**Ref: GREAT NORTH ROAD SOLAR PARK DEVELOPMENT CONSENT ORDER (DCO)
EN010162 – THE EXAMINING AUTHORITY’S WRITTEN QUESTIONS EXQ1**

I write in response to the Examining Authority’s (ExA’s) written questions and requests for information (ExQ2) issued on 4th March 2026 and to provide the response of Nottinghamshire County Council (NCC) (Interested Party [REDACTED]) in relation to those questions which are addressed directly to NCC, or the Interested Parties where relevant to the responsibilities of NCC.

Will Lawrence MRTPI
Planning and Infrastructure Manager
Nottinghamshire County Council

Great North Road Solar and
Biodiversity Park
Environmental Statement

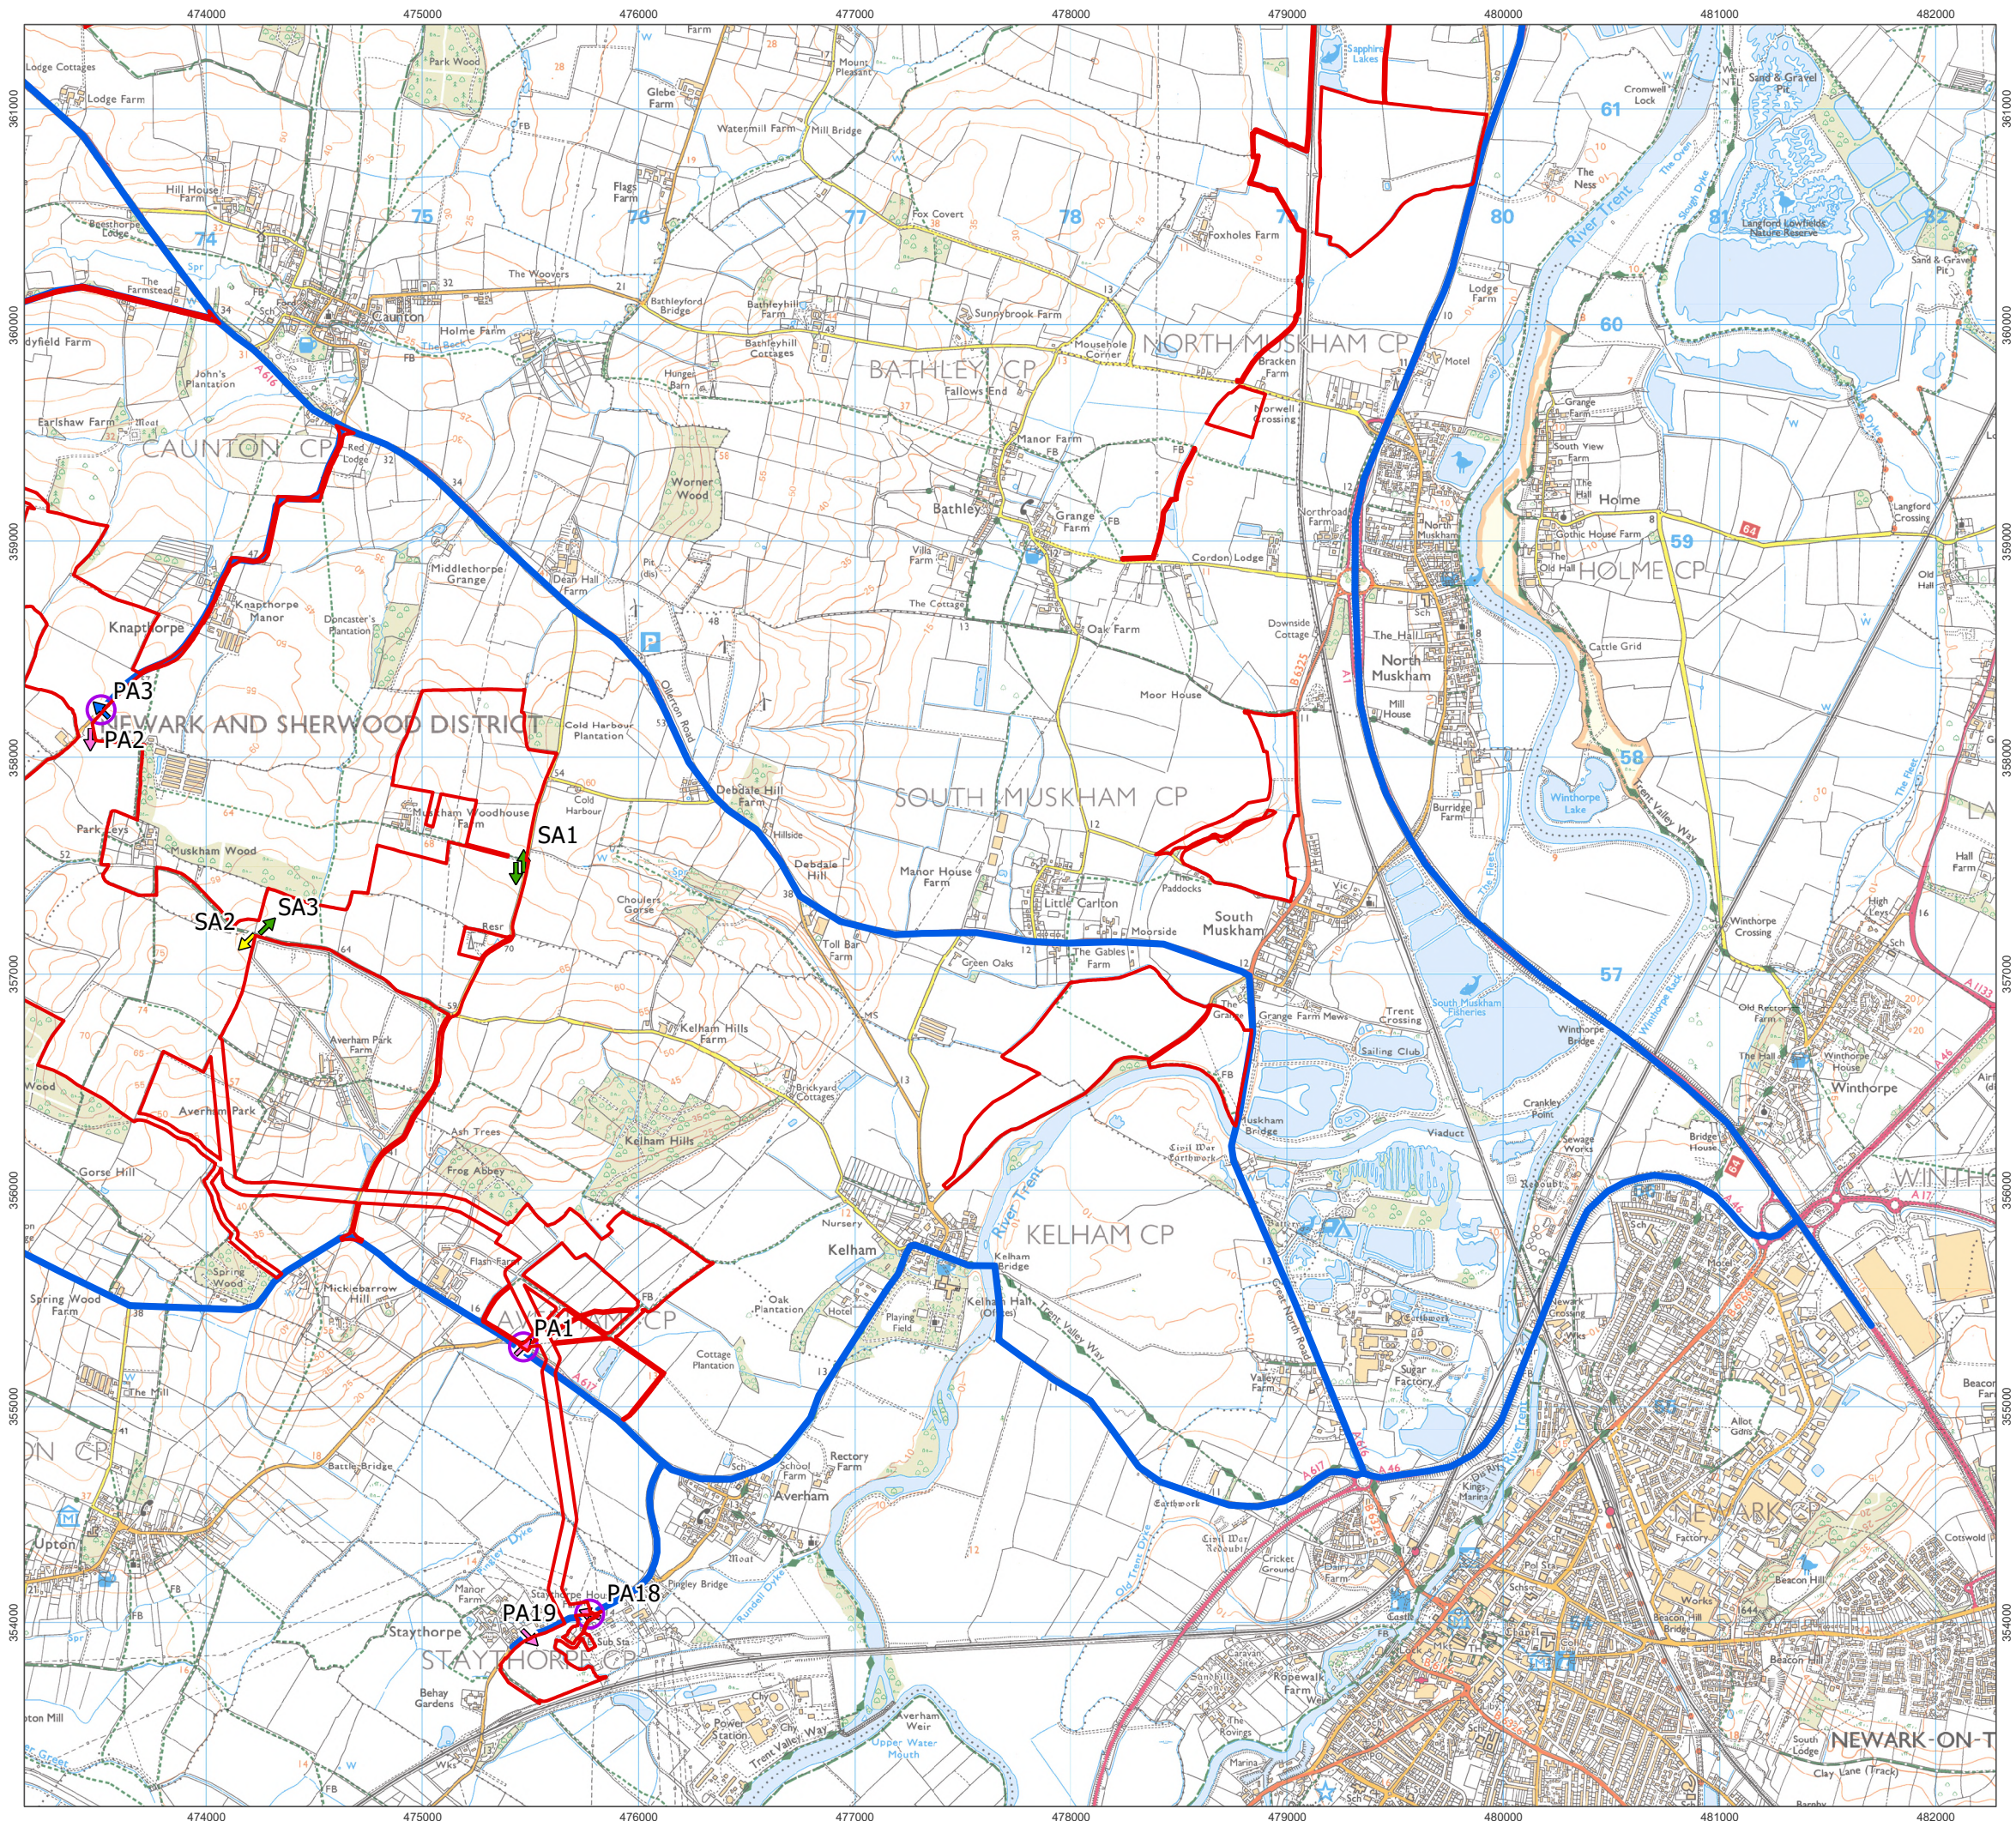
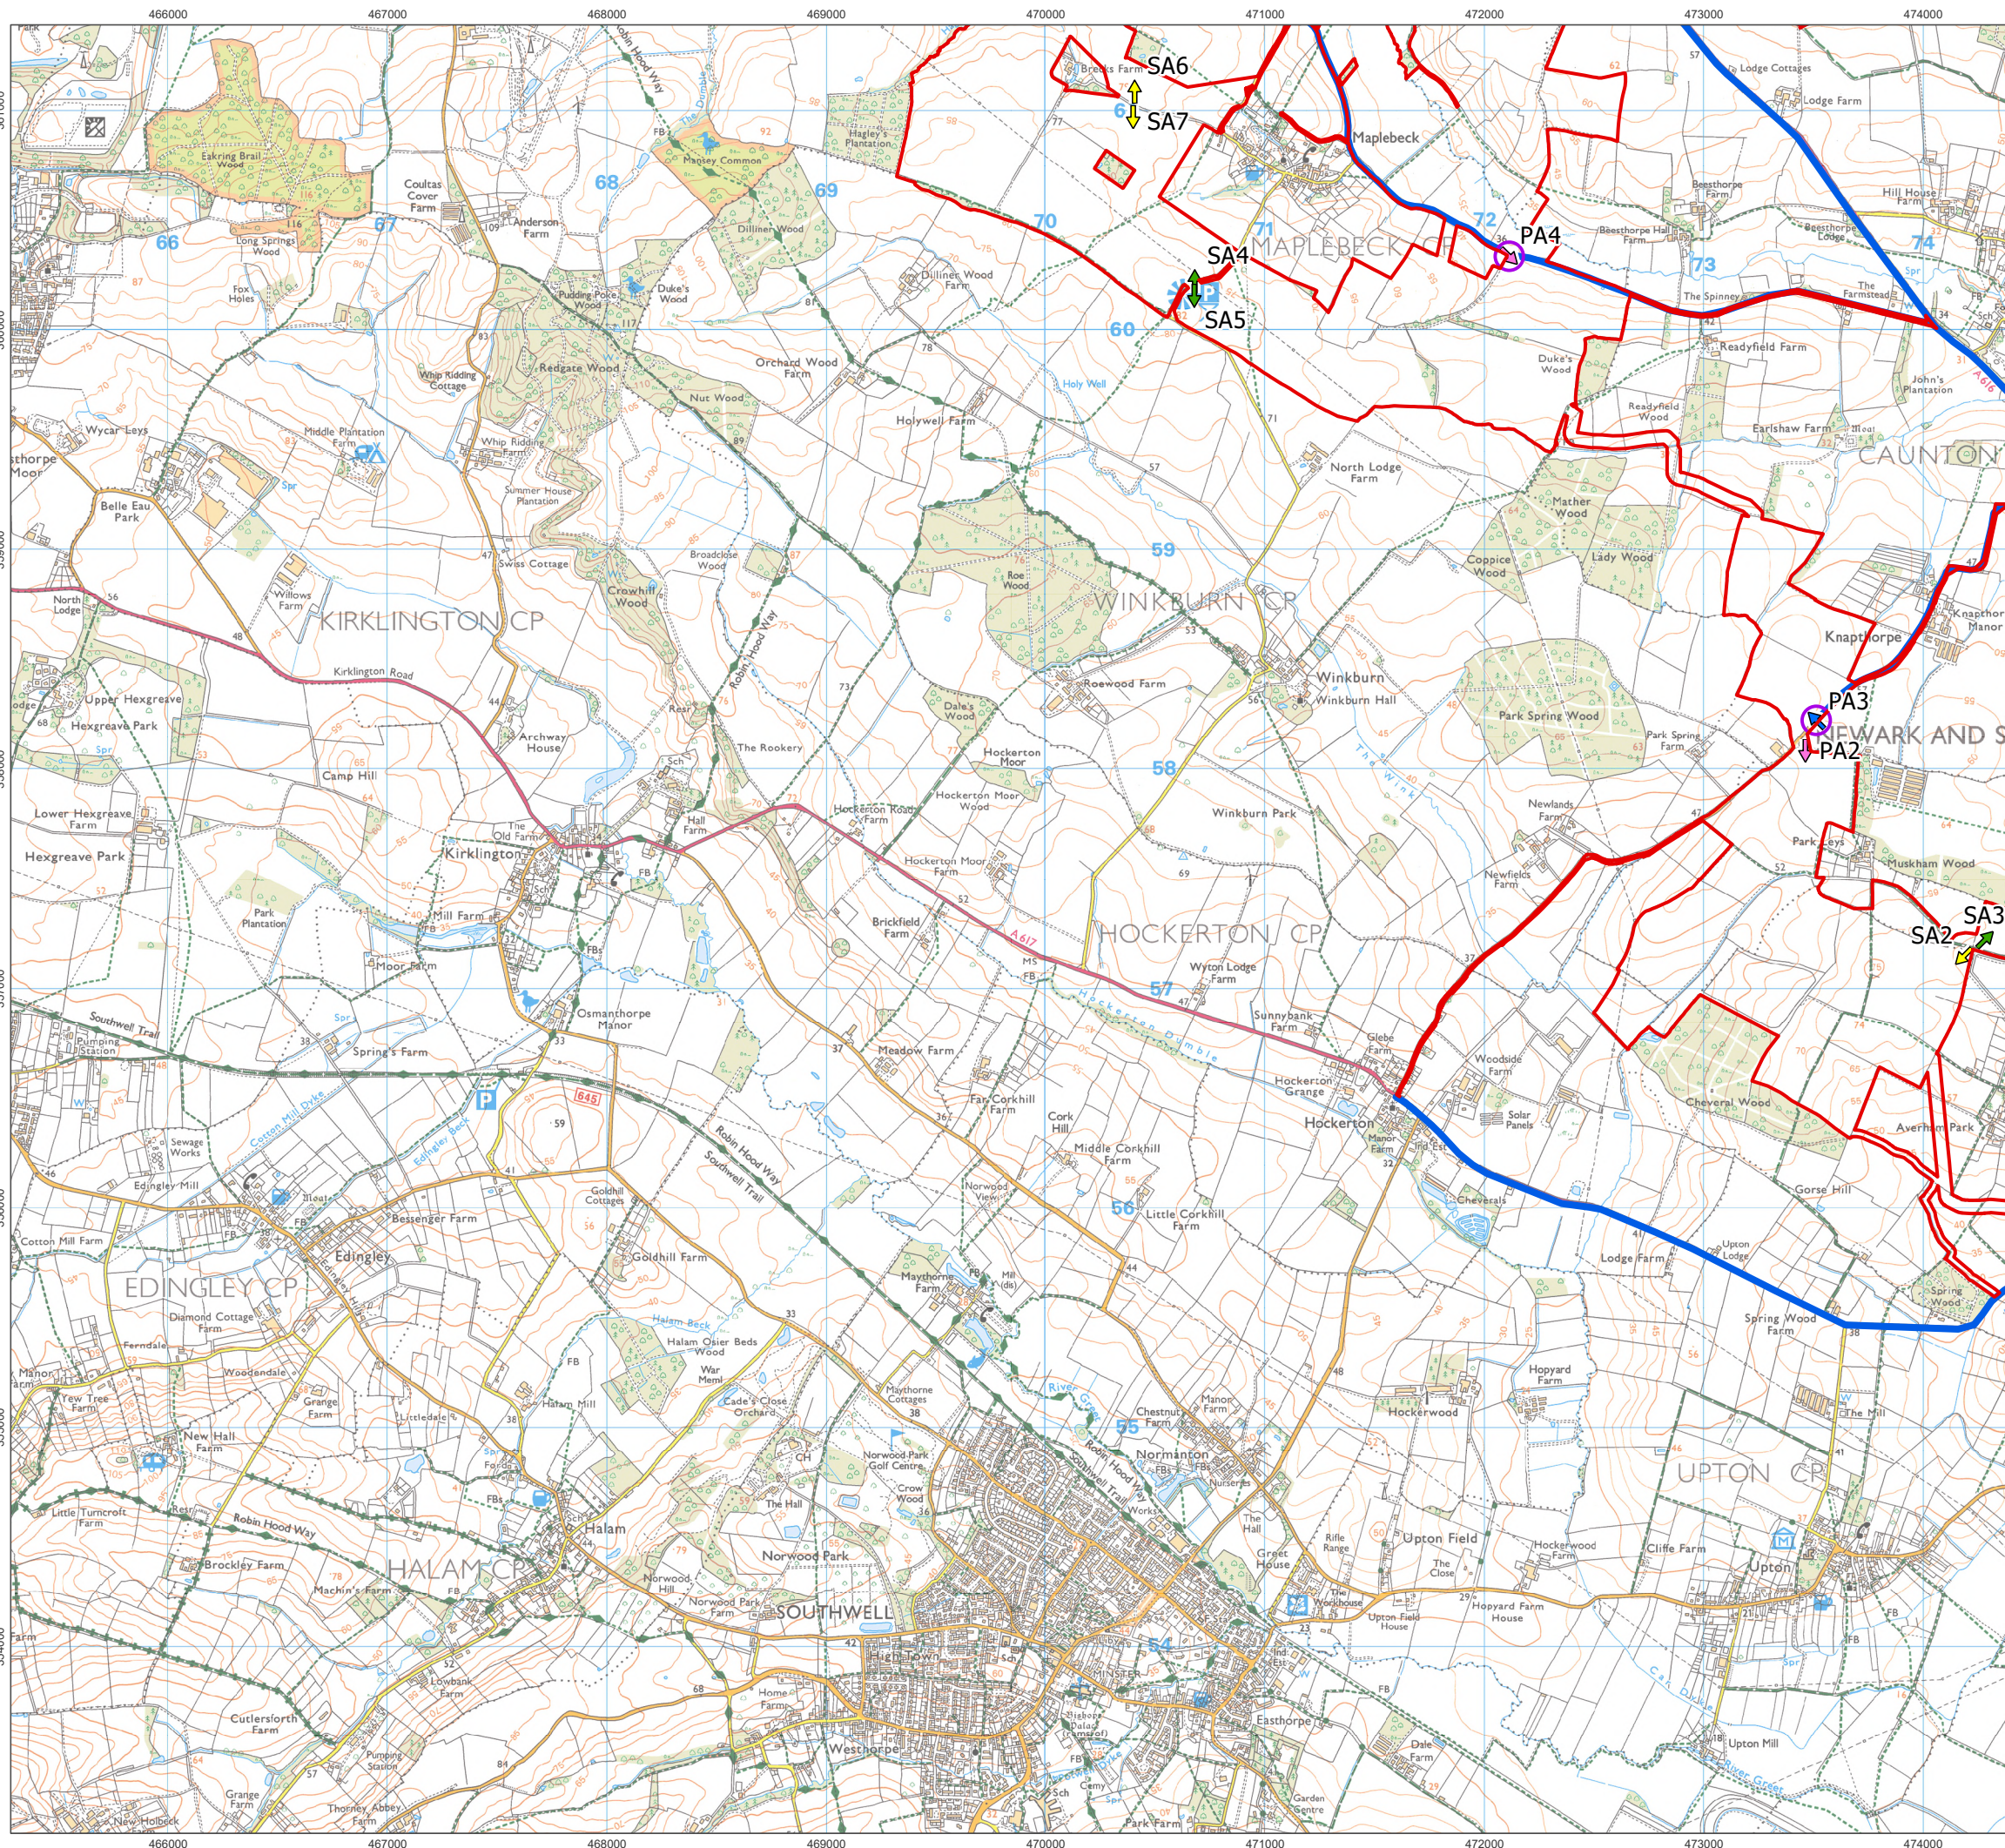
7. Construction Effects			
Q7.2.1	NCC	<p>Site access</p> <p>The ExA understands from the deadline 3 SoCG between the applicant and NCC [REP3-070] that there remain outstanding issues including site access design drawings and safety audits.</p> <p>(a) Does NCC consider that the powers and controls in the dDCO [REP3-005] including articles 16,18 and requirement 14, in association with the outline construction traffic management plan (oCTMP) [REP3-035] are insufficient to prevent an unacceptable impact on highway safety?</p> <p>(b) If the answer is yes please could NCC provide proposed amendments to the dDCO and the oCTMP?</p>	<p><u>Part (a):</u></p> <p>Yes – the controls in the dDCO and the OCTMP are insufficient to prevent an unacceptable impact on highway safety. This is because there are several accesses that do not meet the required visibility standards or have not been properly demonstrated to meet the required visibility standards. It is noted that the applicant is proposing to control visibility deficiencies during the construction phases through vegetation and traffic management, however the vast majority of the accesses are intended to remain in use during operation with no maintenance regime proposed.</p> <p>In total, there are 15 accesses where hedges are required to be coppiced to 0.6m during construction and a further 9 accesses where hedges are required to be trimmed back during construction. Whilst the oCTMP makes allowance for their maintenance during construction, there are no proposals for maintenance during the operational phase, and nor is this considered to be practical where coppicing is required as this results in vigorous growth. The applicant has proposed use of banksmen during the operational phase at such accesses where visibility is deficient. This would mean that banksmen (second operatives) will be crossing roads where visibility has been proven to be deficient. The suggested methodology also introduces a convoluted and unrealistic access regime.</p> <p>There are also highway safety concerns that do not relate to visibility but instead arise from their interaction with the surrounding network. There are 4 accesses with possible layout safety issues (not necessarily visibility related). In the case of PA01, the access is located on the A617 in close proximity to a signal controlled</p>

<p>junction. This creates a risk that drivers approaching on a green signal will not anticipate vehicles ahead slowing or stopping to turn into the access. This risk is heightened during the operational phase, when the access will not be temporarily signed and heavily used, and is instead likely to be used by smaller, faster moving vehicles rather than the larger, slower agricultural vehicles currently associated with the site.</p> <p>Both the above access on the A617 and those proposed on the A616 fall on the Nottinghamshire 'resilient network' which are considered to form part of our major road network, falling just below trunk road category and are therefore of significant importance. It is therefore considered key that such proposals are demonstrated to be acceptable prior to consent.</p> <p>There are 19 accesses where speeds have been assumed which means that the visibility spays are in abeyance. Relevant speed surveys are required to establish if the visibility splays are adequate.</p> <p>Furthermore, the applicant has also not provided any further information in relation to the passing bays and their intervisibility, to confirm safety.</p> <p>In summary, NCC believes that there are fundamental safety issues with a significant number of accesses that would be authorised by the DCO and that the issues cannot be adequately addressed during the operational phase.</p> <p><u>Part (b):</u></p> <p>The Applicant should address the fundamental visibility issues described above and provide a Stage 1 Road Safety Audit for those accesses where there are possible layout safety issues prior to consent being granted to demonstrate that the access points and passing bays are safe.</p>

<p>If these issues cannot be addressed, then the accesses and passing bays should not be authorised by the DCO and alternative locations would need to be assessed by the Applicant. NCC is concerned that the DCO explicitly (via Article 16) provides authority for the undertaker to create accesses in the locations (listed at Schedule 6) which are not demonstrably safe in principle.</p>
